CWWTPR DCO Examination**Submission by Save Honey Hill Group****SHH 34 Response to the Applicant's Responses to Written Representations AW 8.13 [REP2-038]****22 January 2024**

This is an expanded version of SHH34 submitted on 18 December 2023, with responses from Melissa Murphy KC and Esther Drabkin-Reiter, of counsel. The intention to submit this was noted in SHH-037. It is submitted in clean and track change versions. SHH's response refers to Table 2-11 and quotes the paragraph numbers in the SHH WR as used in REP2-038

Viewpoint 25: Users of shared foot/cycle path along Horningsea Road looking south-east

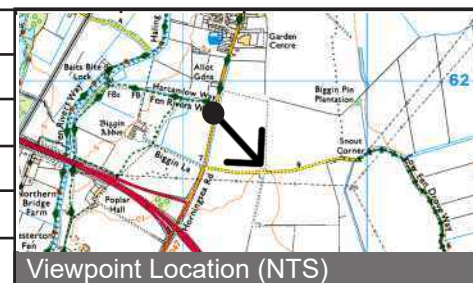
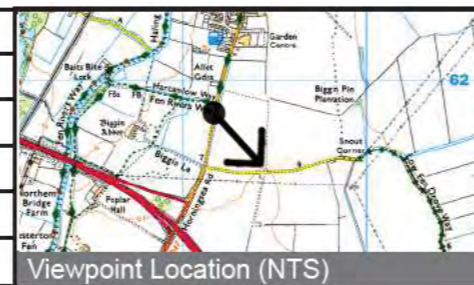
<p>significant impact on visual amenity along this stretch of vegetated river bank, particularly when viewed northwards towards the woodland area and Baist Bite Lock.</p> <p>VP25 SHH maintains the position that this viewpoint should be awarded a high sensitivity rating.</p> <p>VP5 The Applicant in its Response refers to Newmarket Road, however this viewpoint is intended and shown in Fig 15.1 (AS-048) as being on High Ditch Road looking NW towards the PD. The conclusions drawn in SHH 04 (REP-171) relating to VP5, VP7, and VP9 stand.</p> <p>VP 28 SHH notes and accepts the Applicant's comments.</p>

**Viewpoint 22: Residents of Poplar Hall and Poplar Hall Farmhouse looking south, residents of Red House Close looking north and users of Footpath Fen Ditton 85/6**

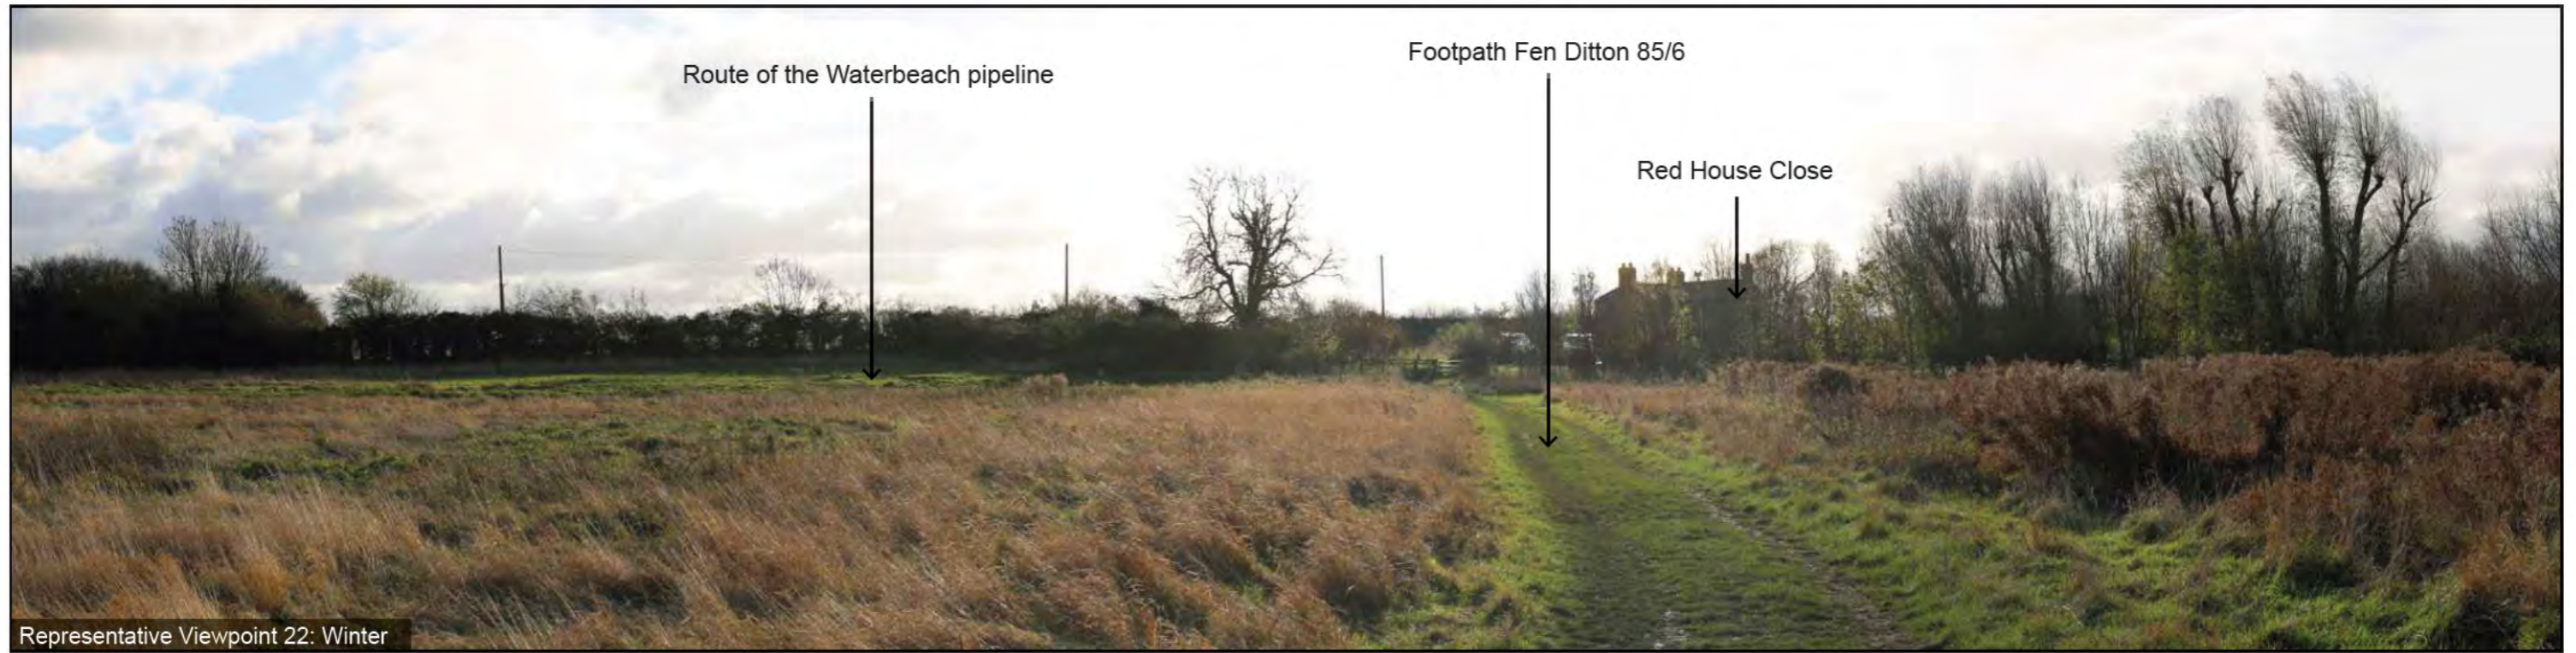
8.2.8	Viewpoints	<p>SHH notes the Applicant's guidance about viewing photomontages and trusts that the ExA and other parties will be provided with prints at A1 size to enable this to happen.</p> <p>SHH notes the Applicant's comments on VP 23. In the case of Footpath 85/6, SHH raises concerns here about the sustainability of the mitigation proposed to cover the roof of the discharge outfall from view. The roof is specified as being at or around ground level. In reality, the dDCO has been amended to allow that structure to deviate to be up to 500mm higher than has been designed and assessed. In the context of the low riverbank, this is a potentially substantial upper deviation. Whether it remains practicable to cover the main structure away from the river bank with soil and grass remains to be demonstrated. This will have an adverse</p>	SHH REP-171 AW 5.3.15, (AS-048) AW 5.2.15, (AS-034)
